## Appeal Decision

**Appeal Ref: APP/R5510/D/24/3356623**

**65 Hunters Grove, Hayes, Hillingdon UB3 3JE**

- The appeal is made under section 78 of the Town and Country Planning Act 1990 (as amended) against a refusal to grant planning permission.
- The appeal is made by Saud Ahmad against the decision of the Council of the London Borough of Hillingdon.
- The application Ref is 14399/APP/2024/1703.
- The development proposed is a single storey rear extension.

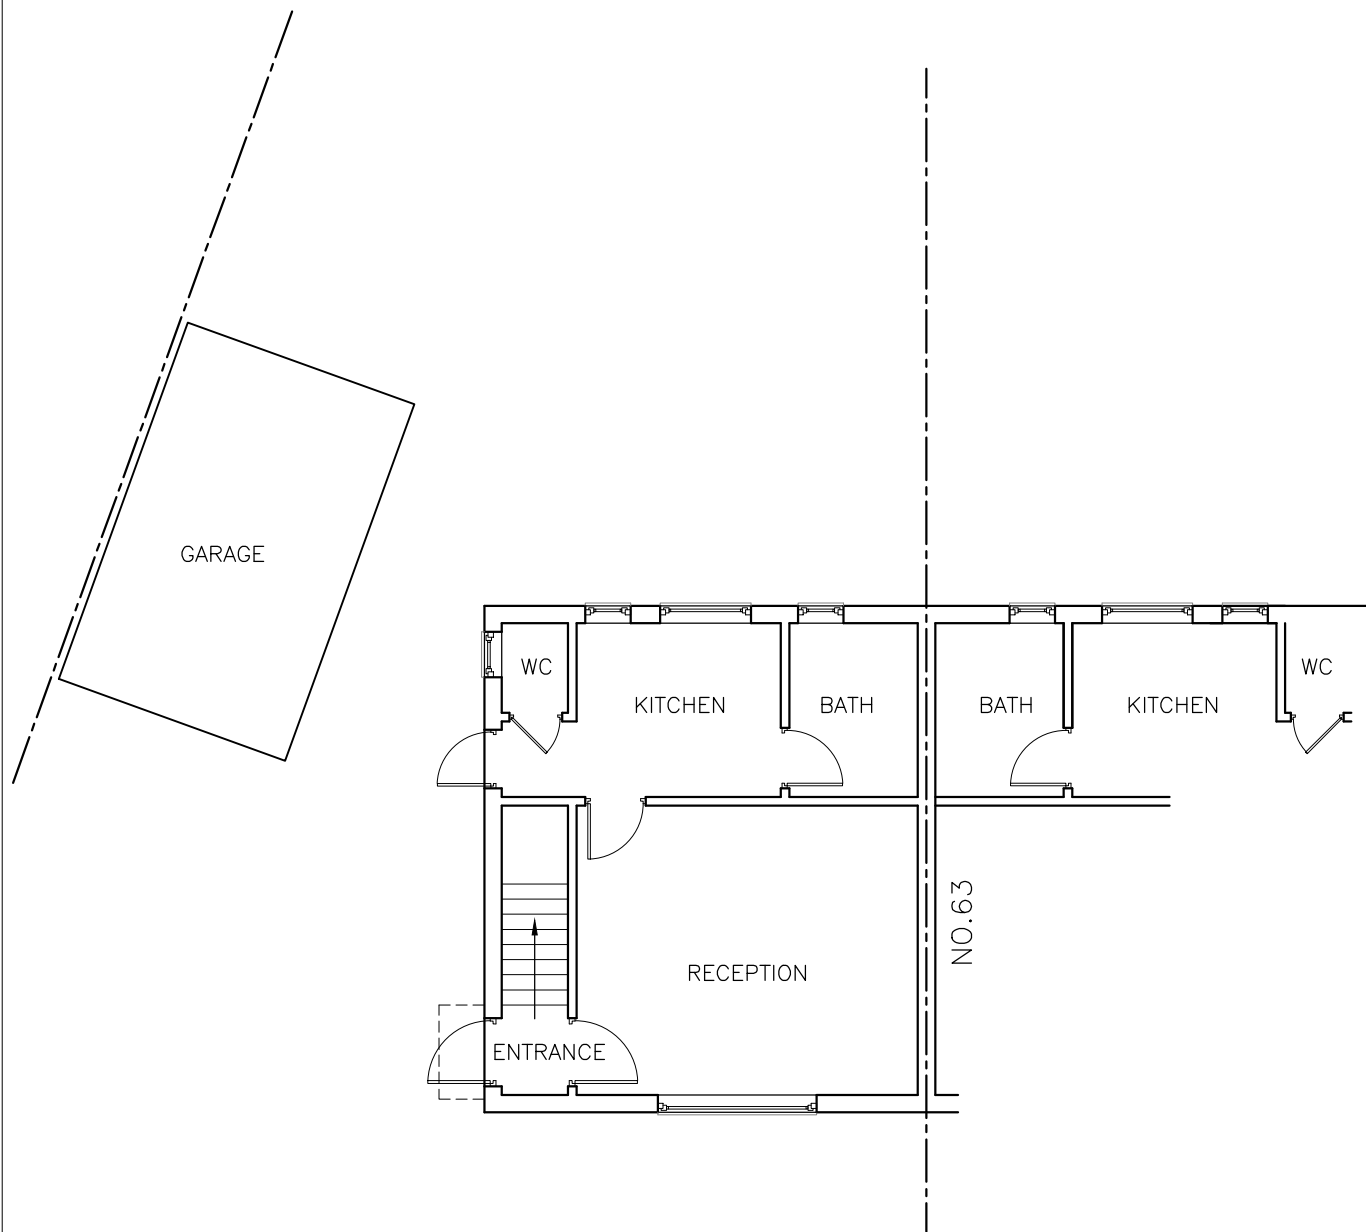
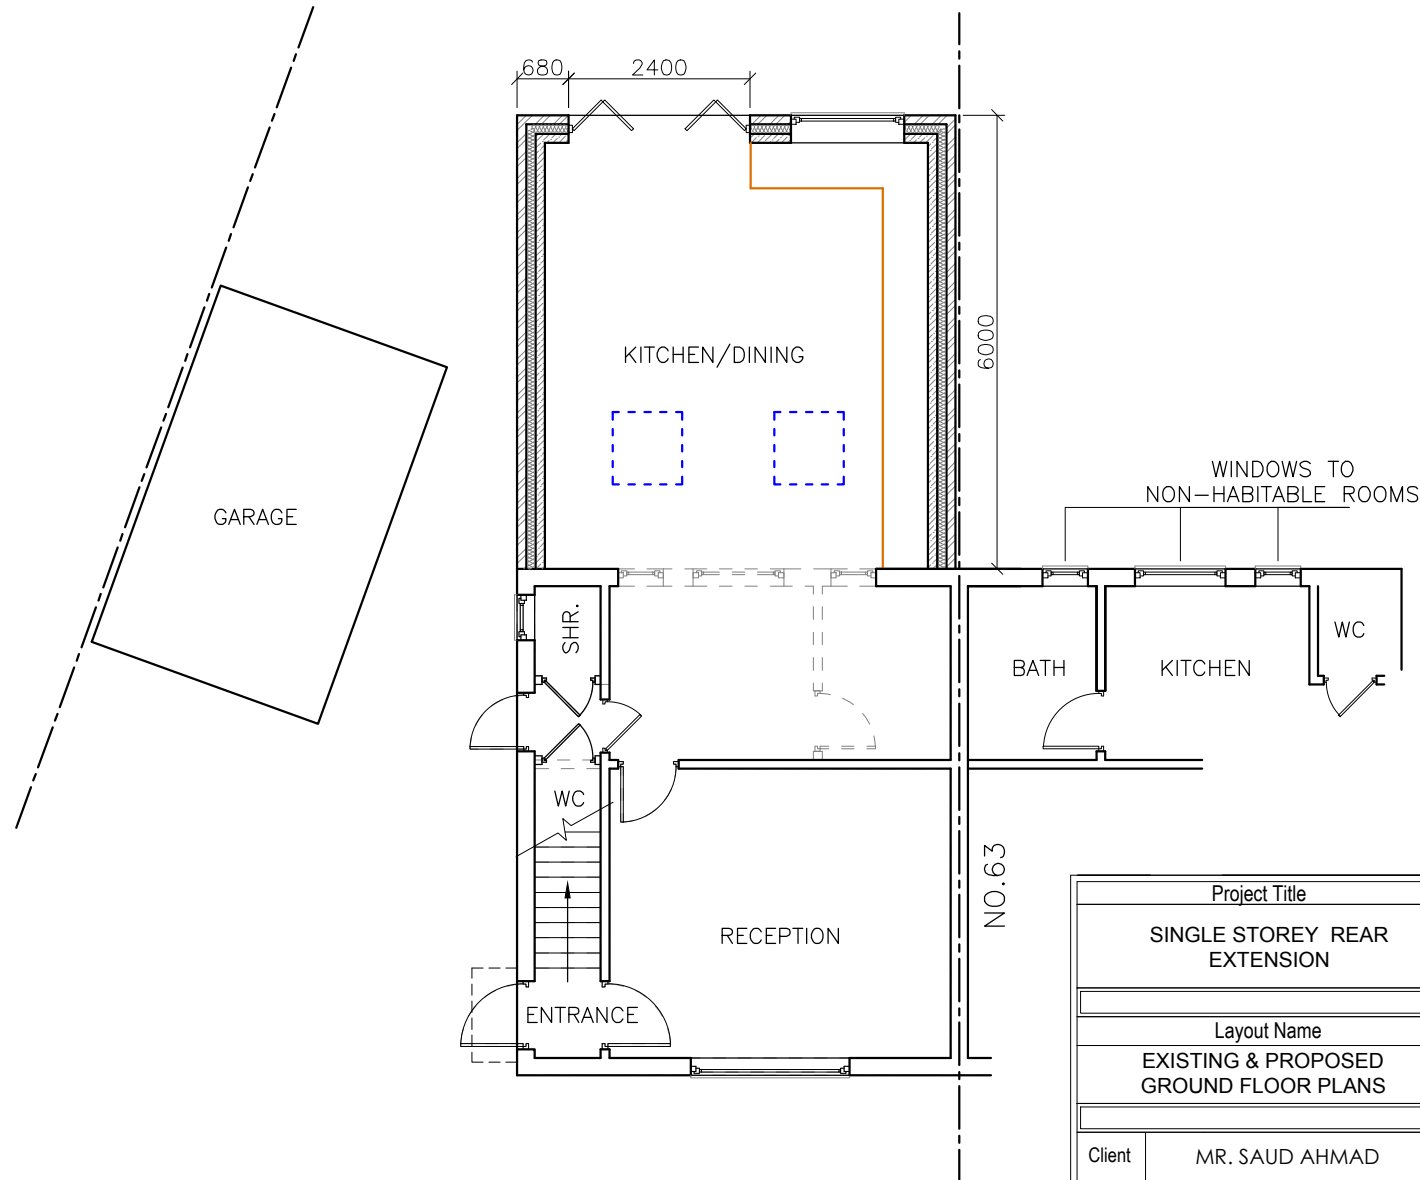
4. The appeal property is a two storey semi-detached dwelling located on the corner of Hunters Grove and Crossway. It has a detached garage to the side and some off-road parking at the front. Its semi-pair is No. 63. Hunters Grove and Crossway are residential in nature with semi-detached dwellings built in a similar style and pattern. The appeal property lies on the edge of 'East and West Walk, Botwell Area of Special Local Character'. The appeal property is largely unaltered and overall makes a positive contribution to the character and appearance of the area through contributing to the general uniformity of the style and pattern of development in the vicinity.
5. The proposed single storey rear extension would span the full width of the property and project 6m beyond the rear elevation. The extension would almost double the

size of the ground floor of the host dwelling, appearing at odds with the original plan form. The proposed extension would not step in from the flank wall of the main dwelling but would be flush with it. That lack of articulation would contribute to the appearance of a dominant extension. The large scale and mass of the proposed extension would not be subordinate to the modestly sized host dwelling.

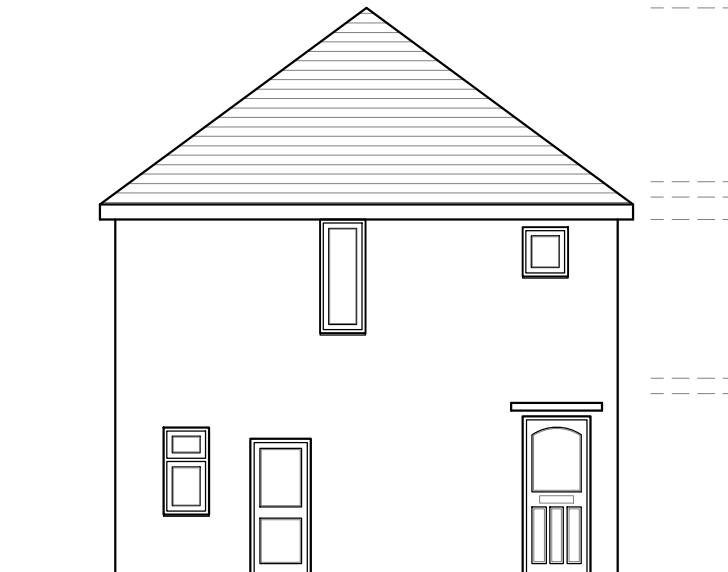
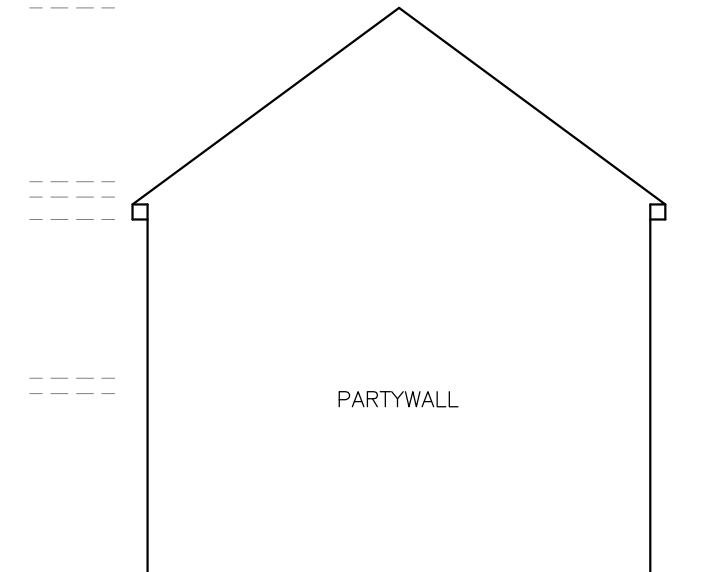
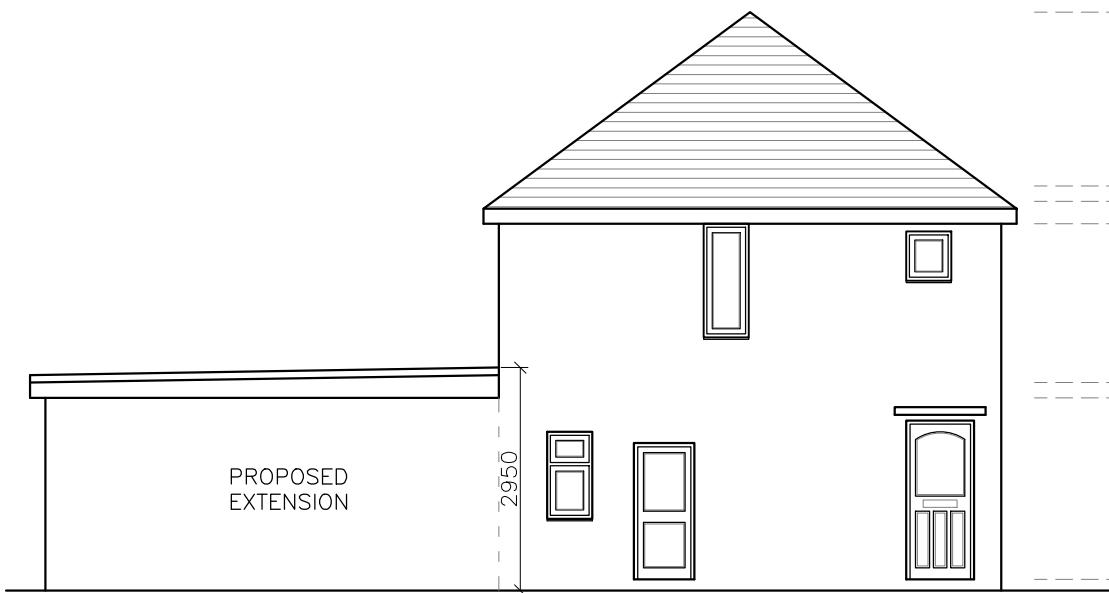
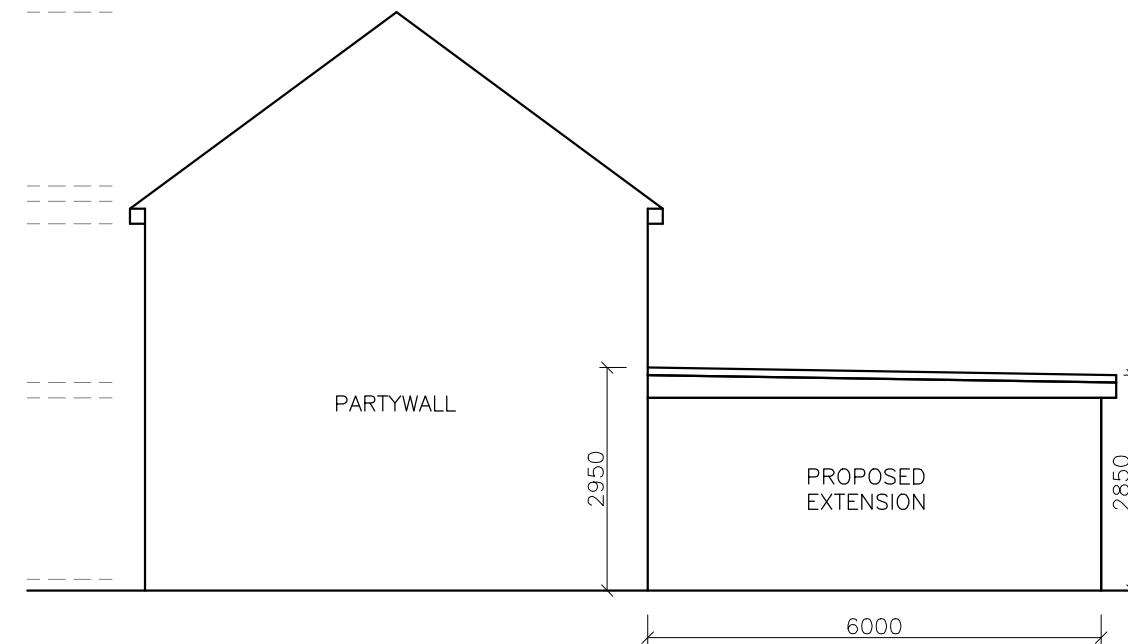
8. Although the proposed extension would be single storey, it would nevertheless be clearly visible above the wall along the common boundary. The proposed extension would cause a sense of enclosure for the occupants of No. 63 owing to its proximity, depth and height. When looking out the kitchen window and using the part of the garden closest to the dwelling, the occupants would find the extension overbearing and enclosing. Overall, the impacts for the occupants of No.63 in respect of their outlook and their enjoyment of light would be significantly different from the existing impact of the brick wall that currently separates the properties.
